CITY OF ALBUQUERQUE

Planning Department Transportation Development Services

December 18, 2015

Re: Advanced Auto Parts, 4910 Central Ave SE
Request for Certificate of Occupancy- Transportation Development
Architect's Stamp dated 06-18-15 (K17-D110)
Certification dated 12-17-15

SITE PLAN

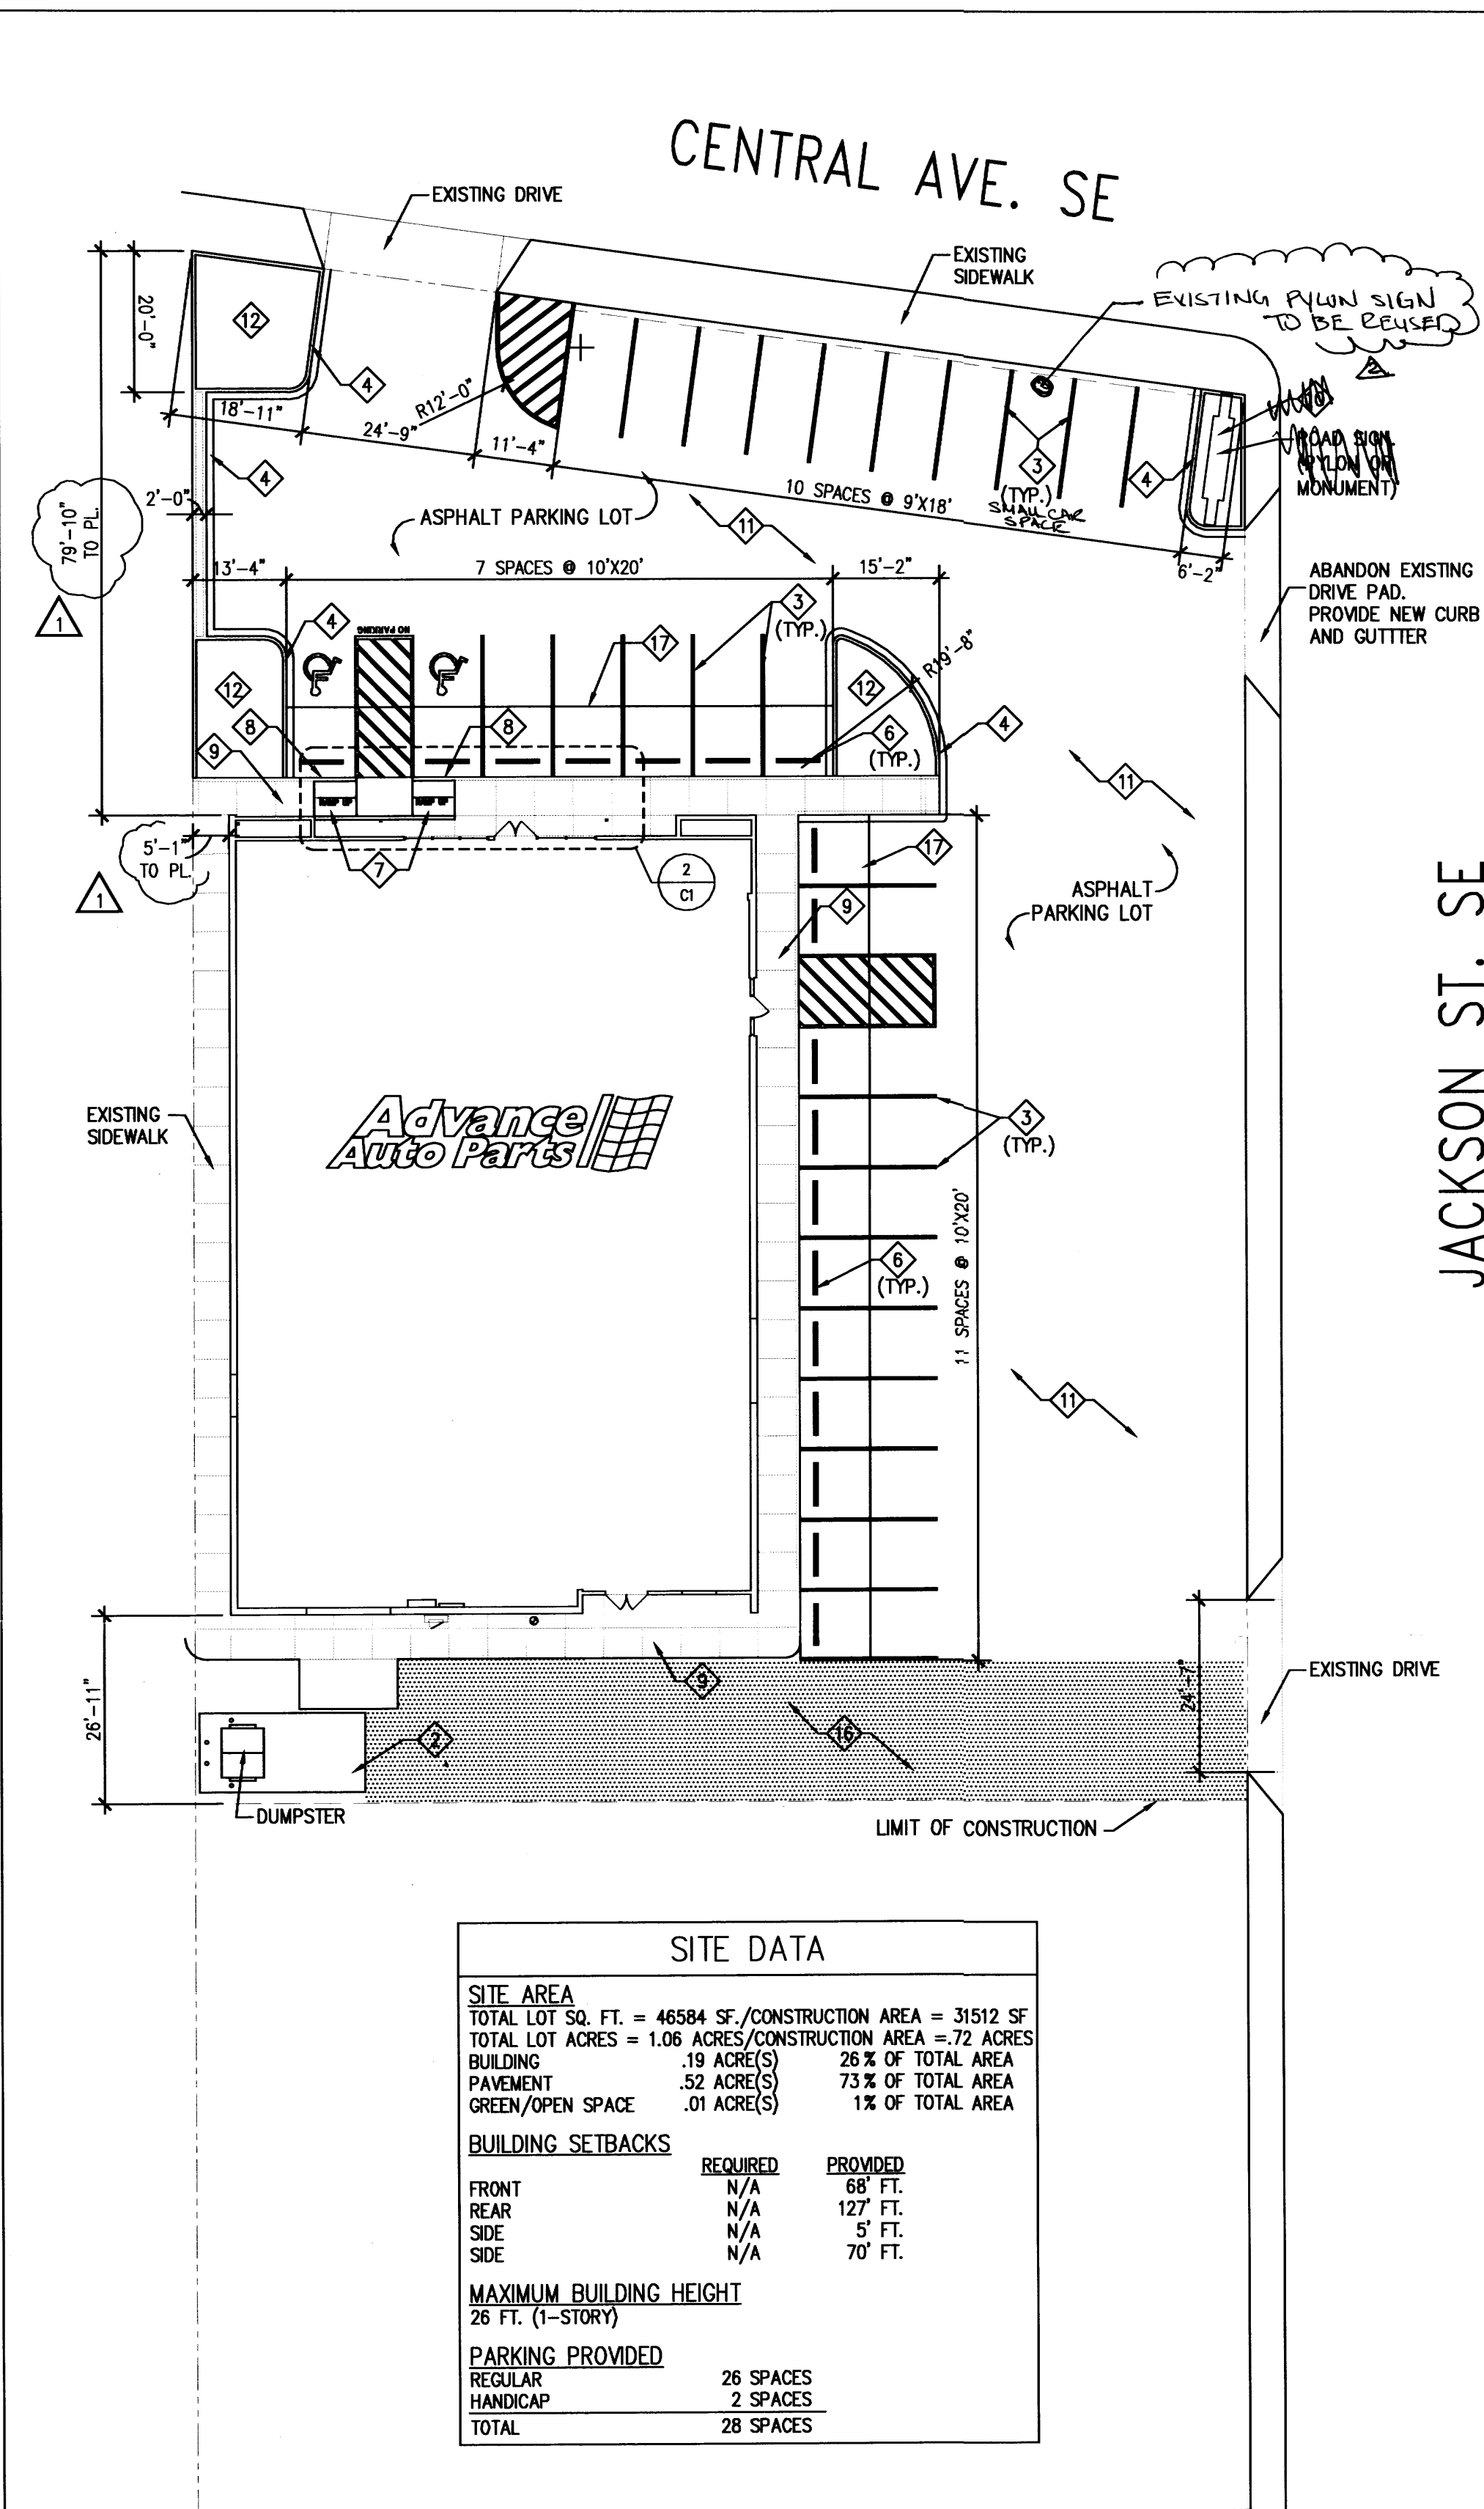
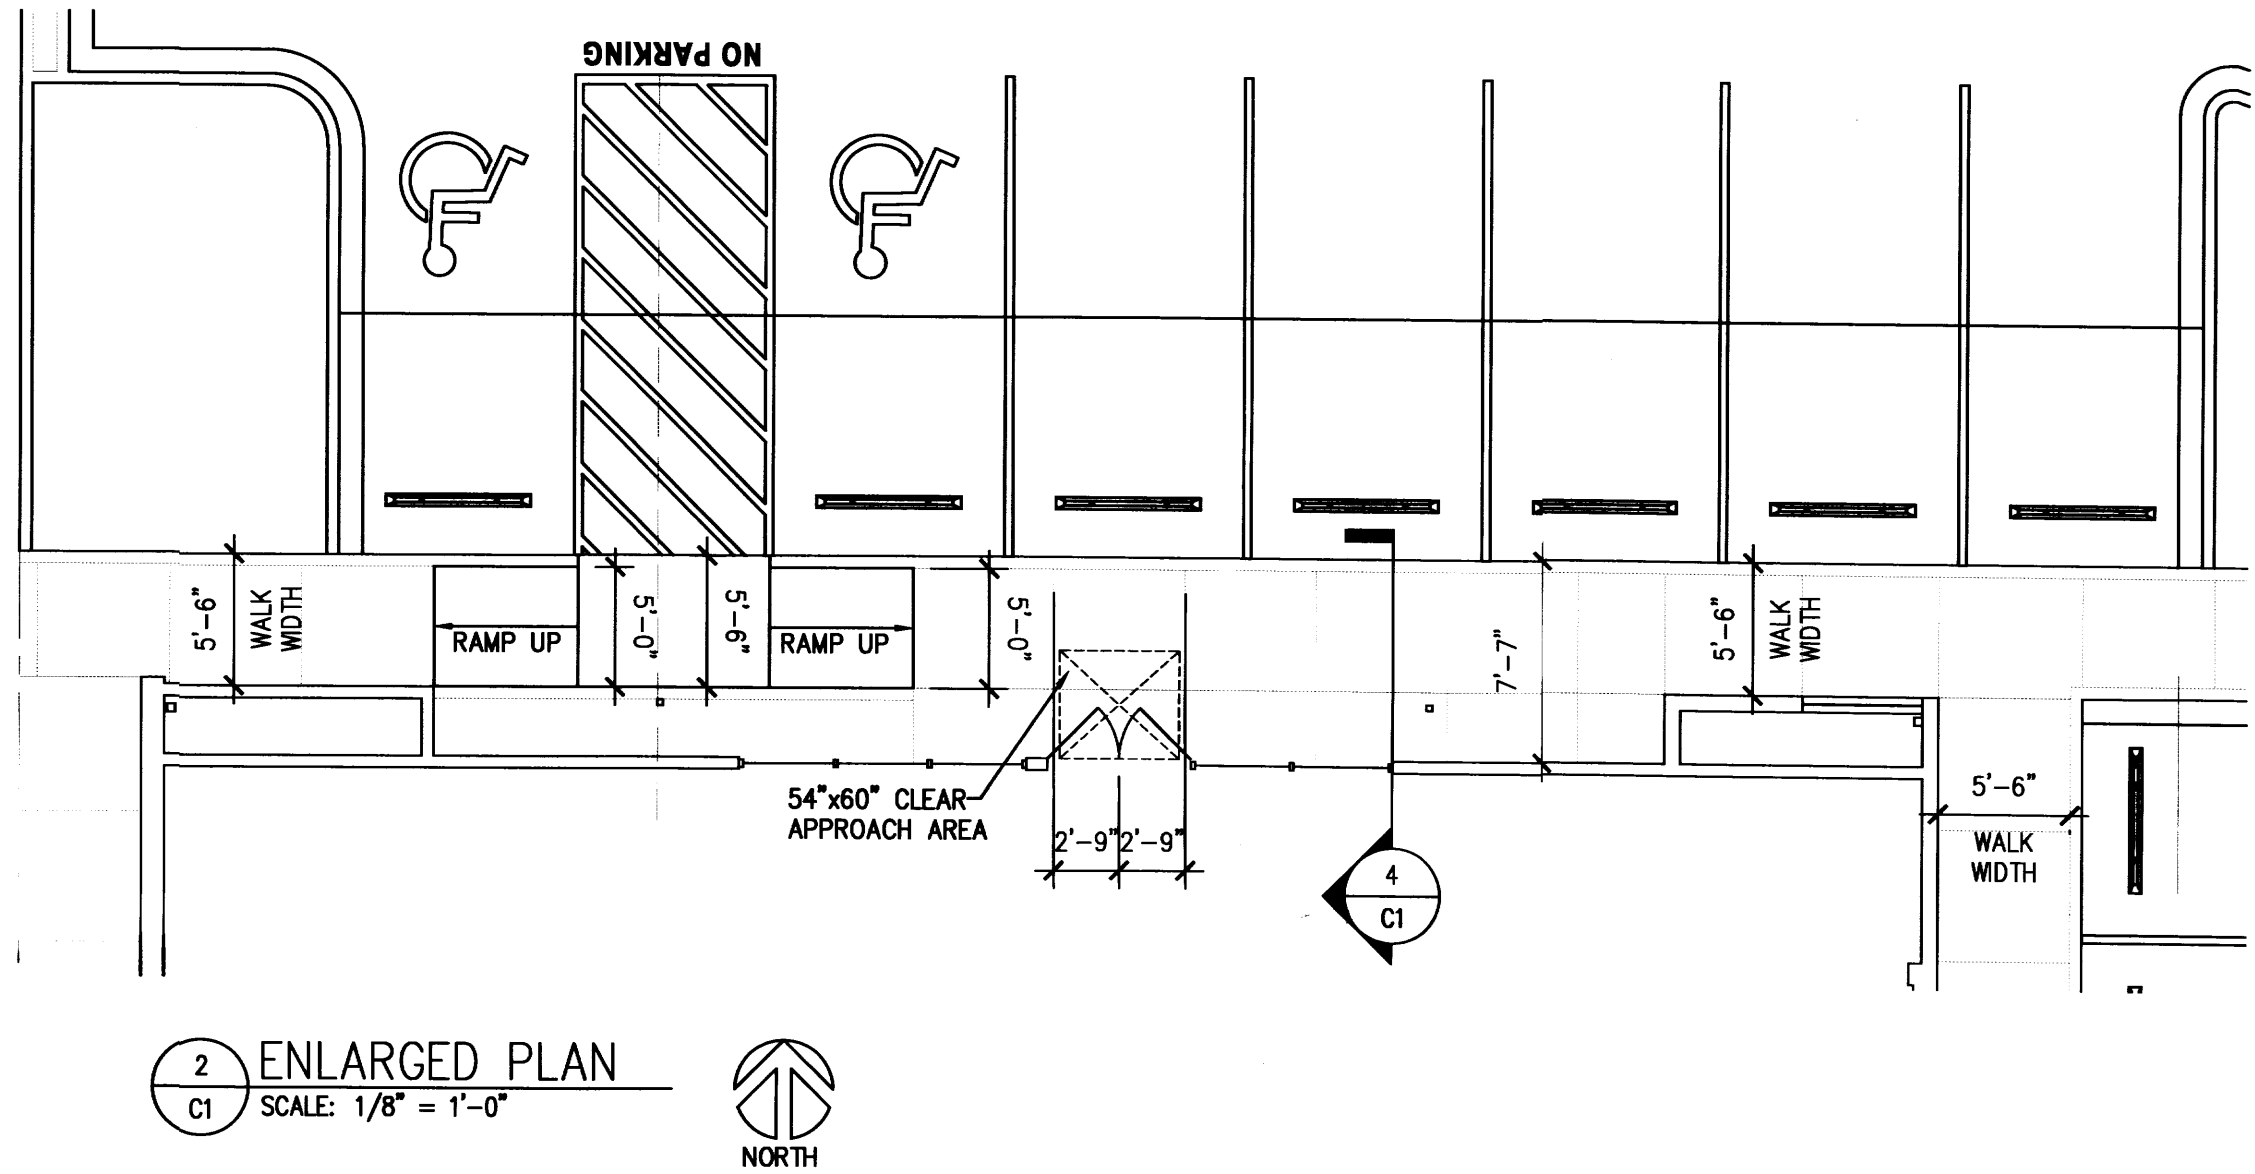
- Addition of 4 ft. sidewalk along eastern frontage per COA Standards, along with a bump out around existing power pole.
- Upon completion and submittal for Final CO, Certification date language must state that project is being certified in accordance to approved plan and it's stamp date.
